Our ref: HA/2022/124213/01-L01
Your ref: M/6/22/PL

DEMOLITION OF EXISTING BUNGALOW AND ERECTION OF 1 NO 2-STOREY, 4-BEDROOM DETACHED HOUSE WITH 3 NO OFF ROAD CAR PARKING SPACES.

88 ANCTON WAY ELMER MIDDLETON-ON-SEA PO22 6JP

Drawing Title:
Proposed Plans

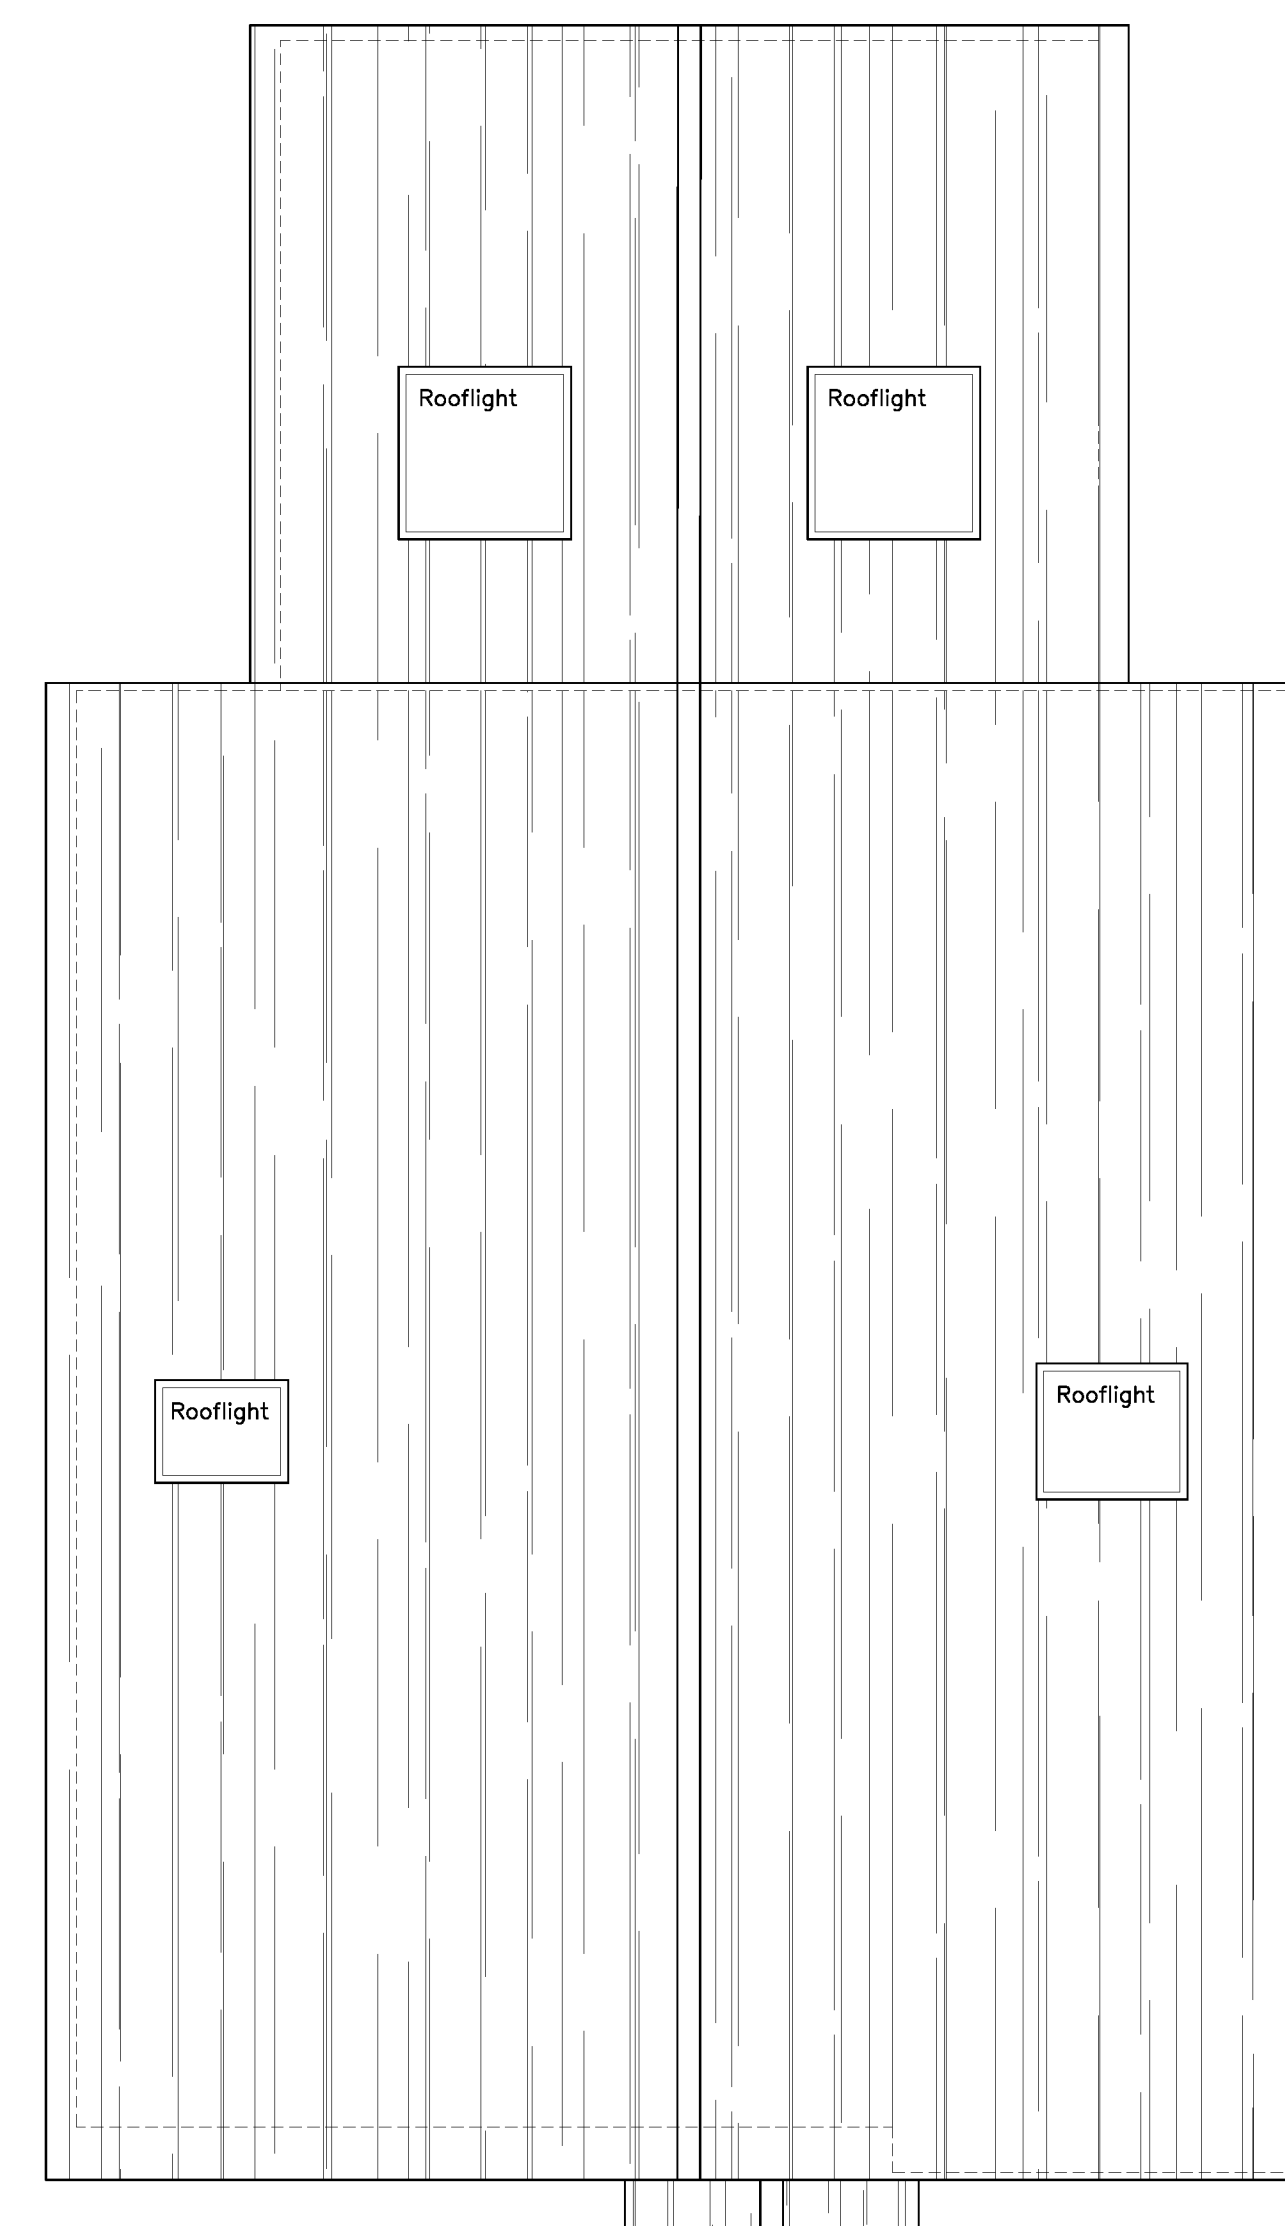
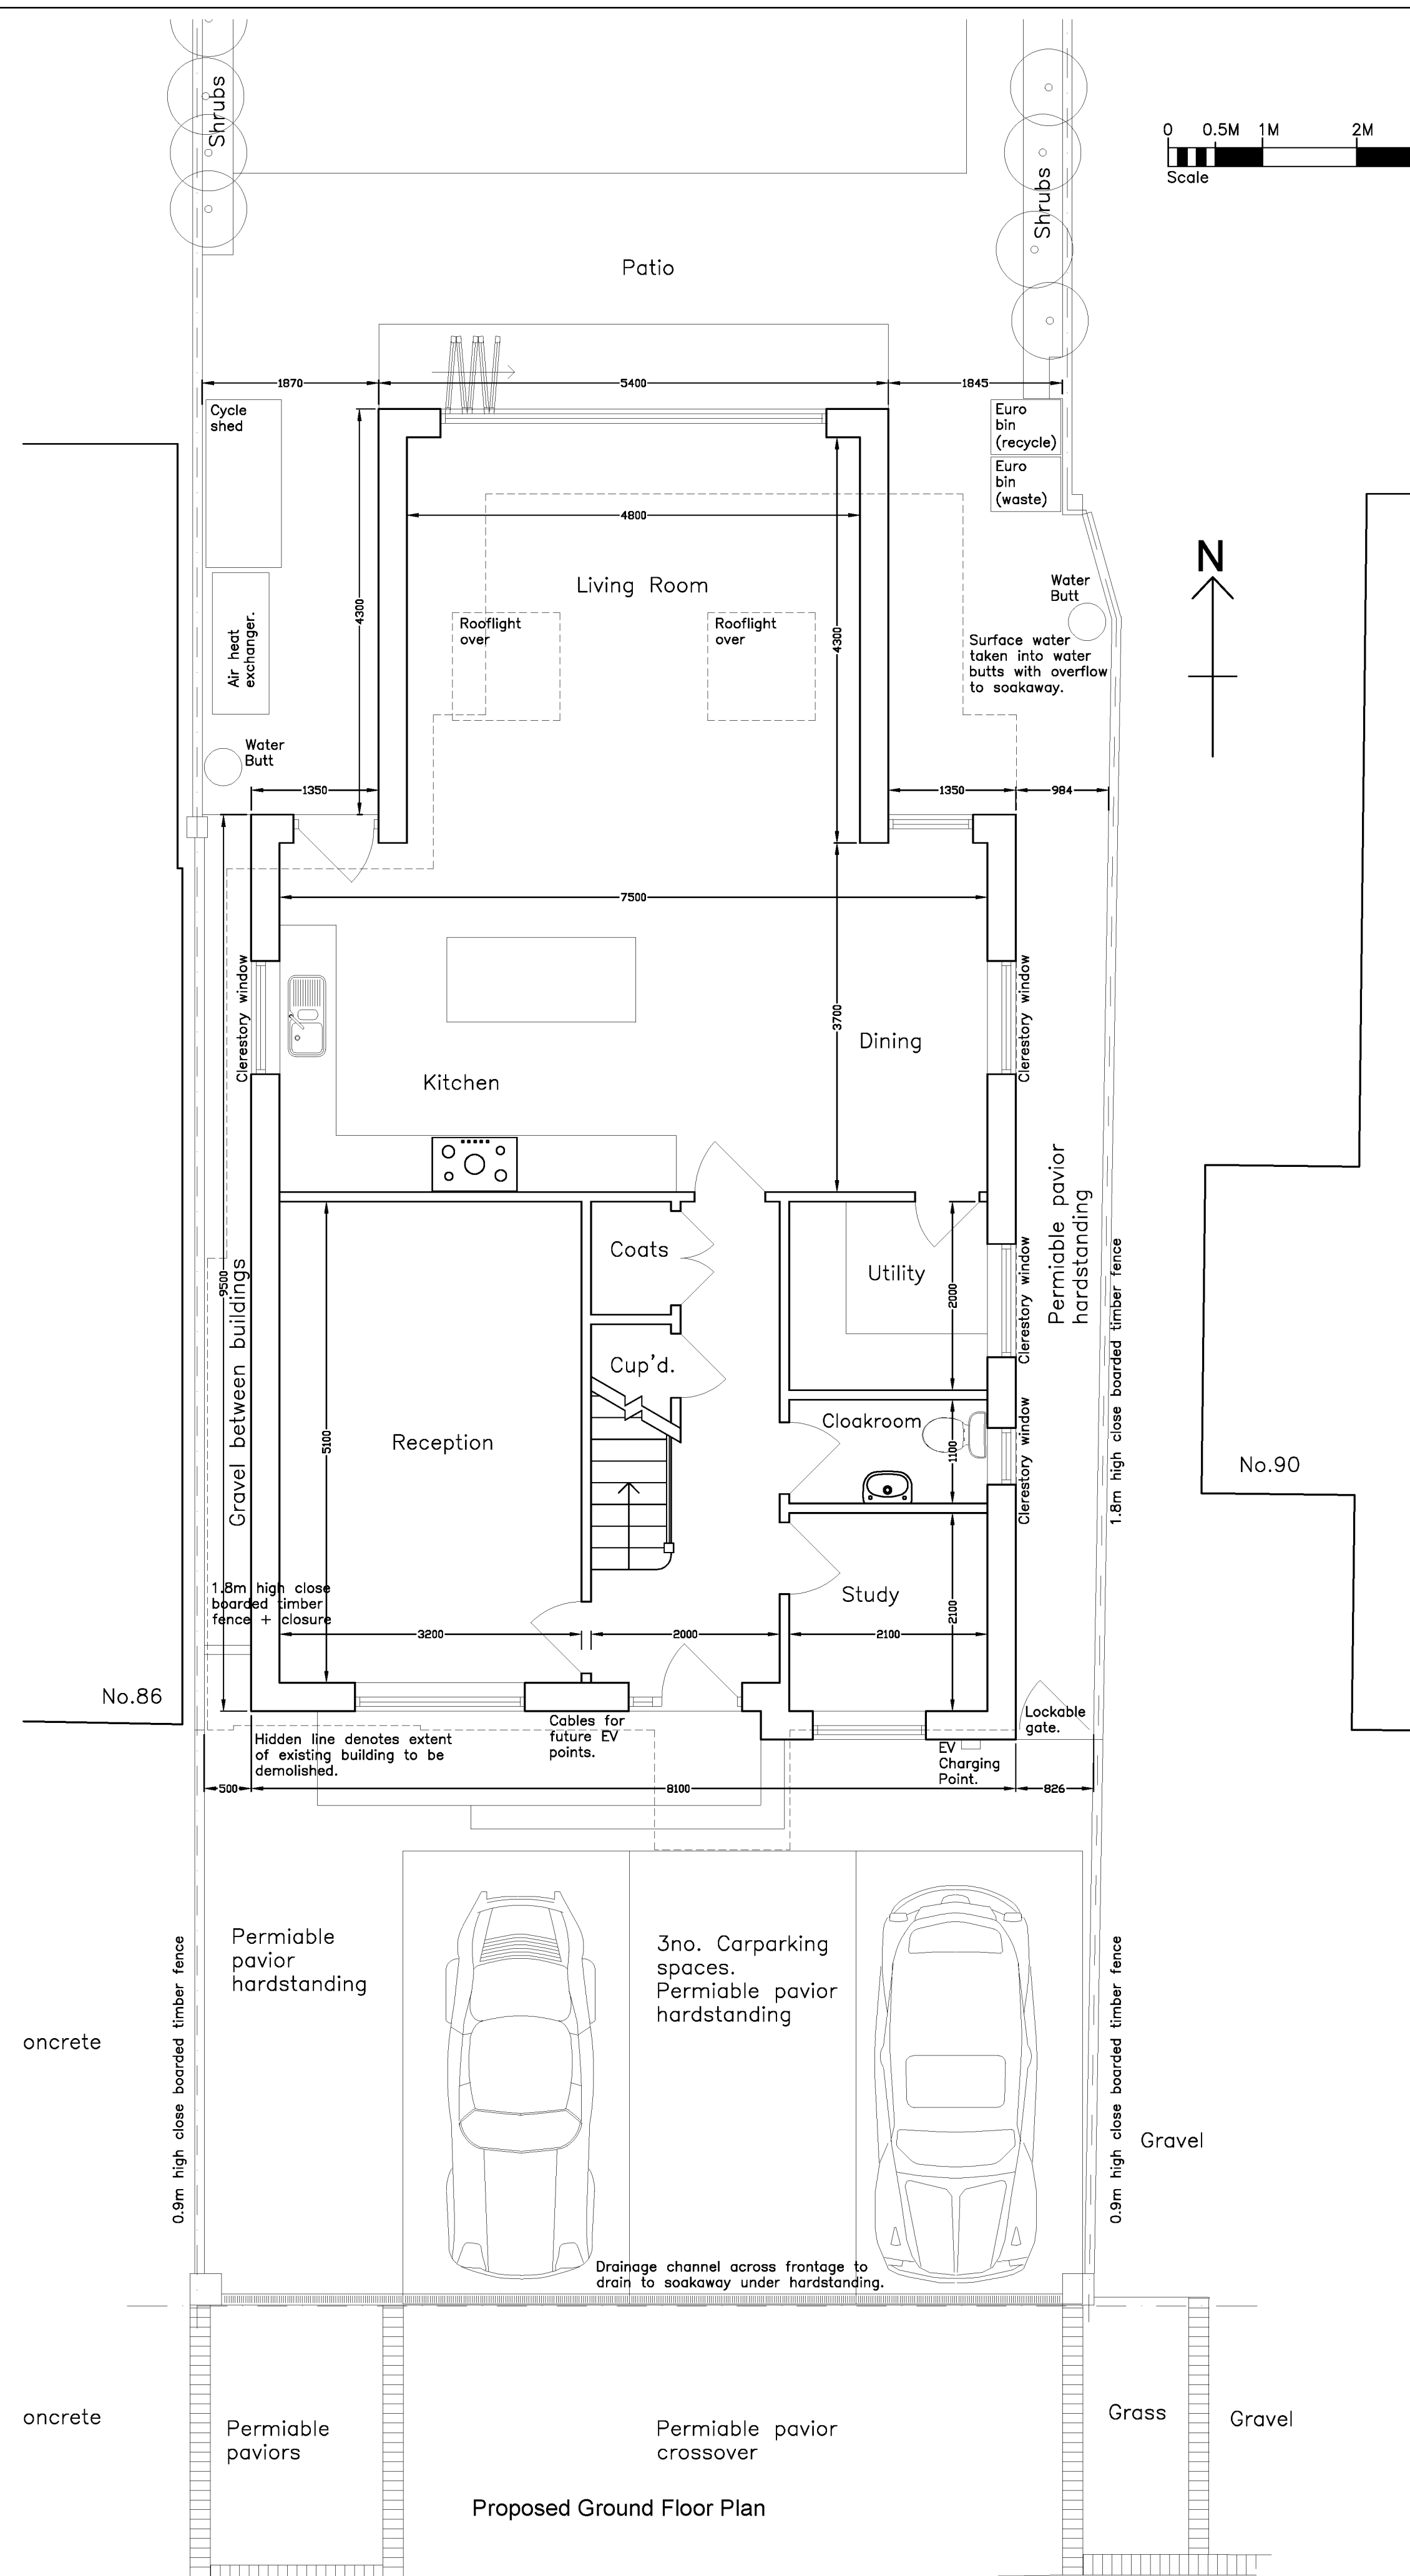
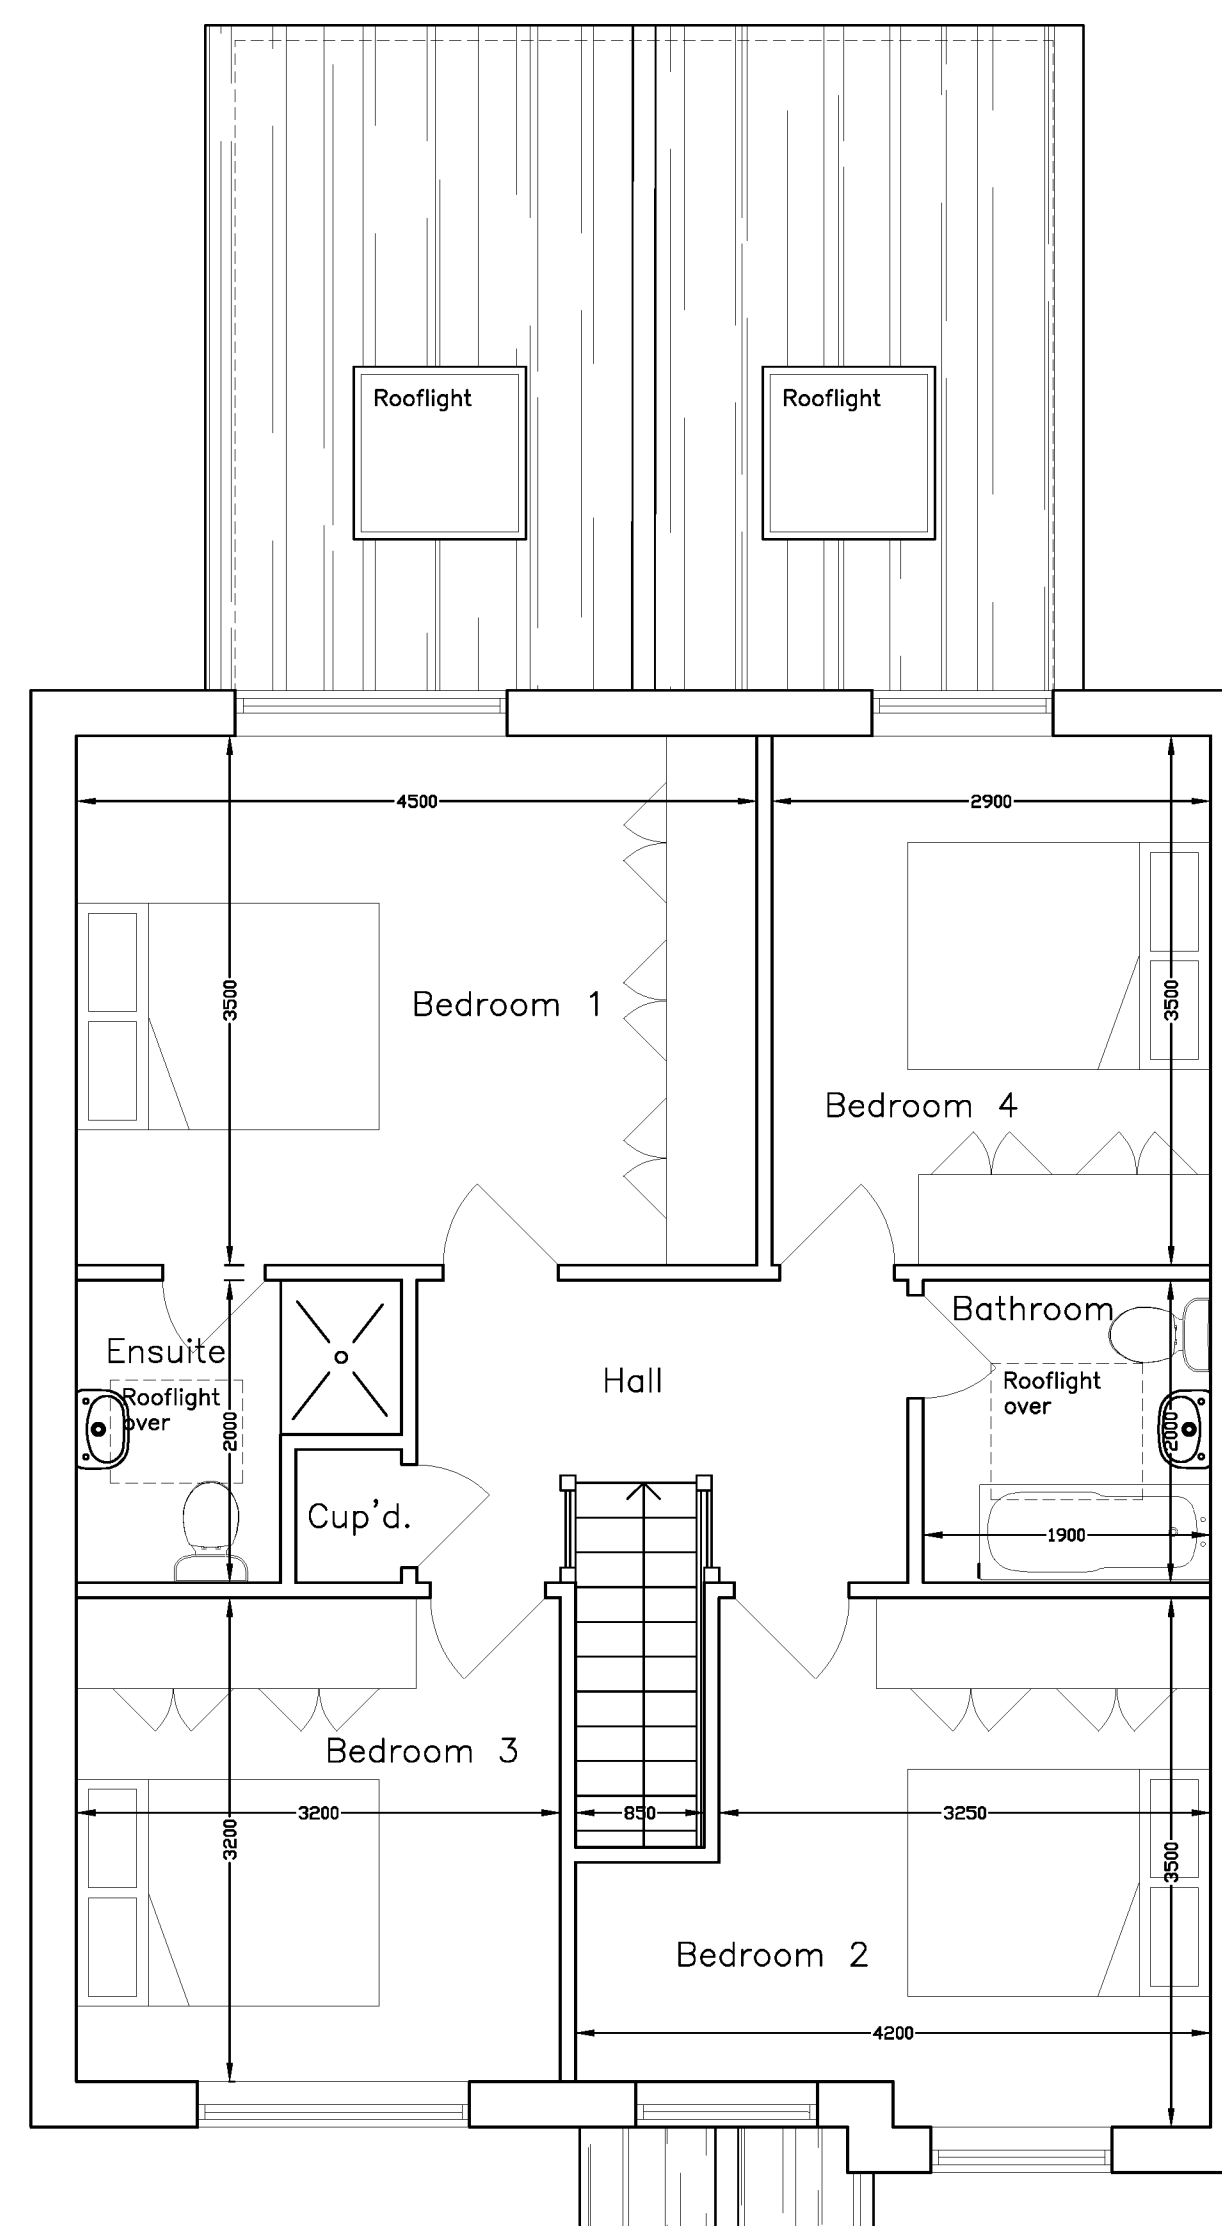
- **All sleeping accommodation will be located on the first floor and above**
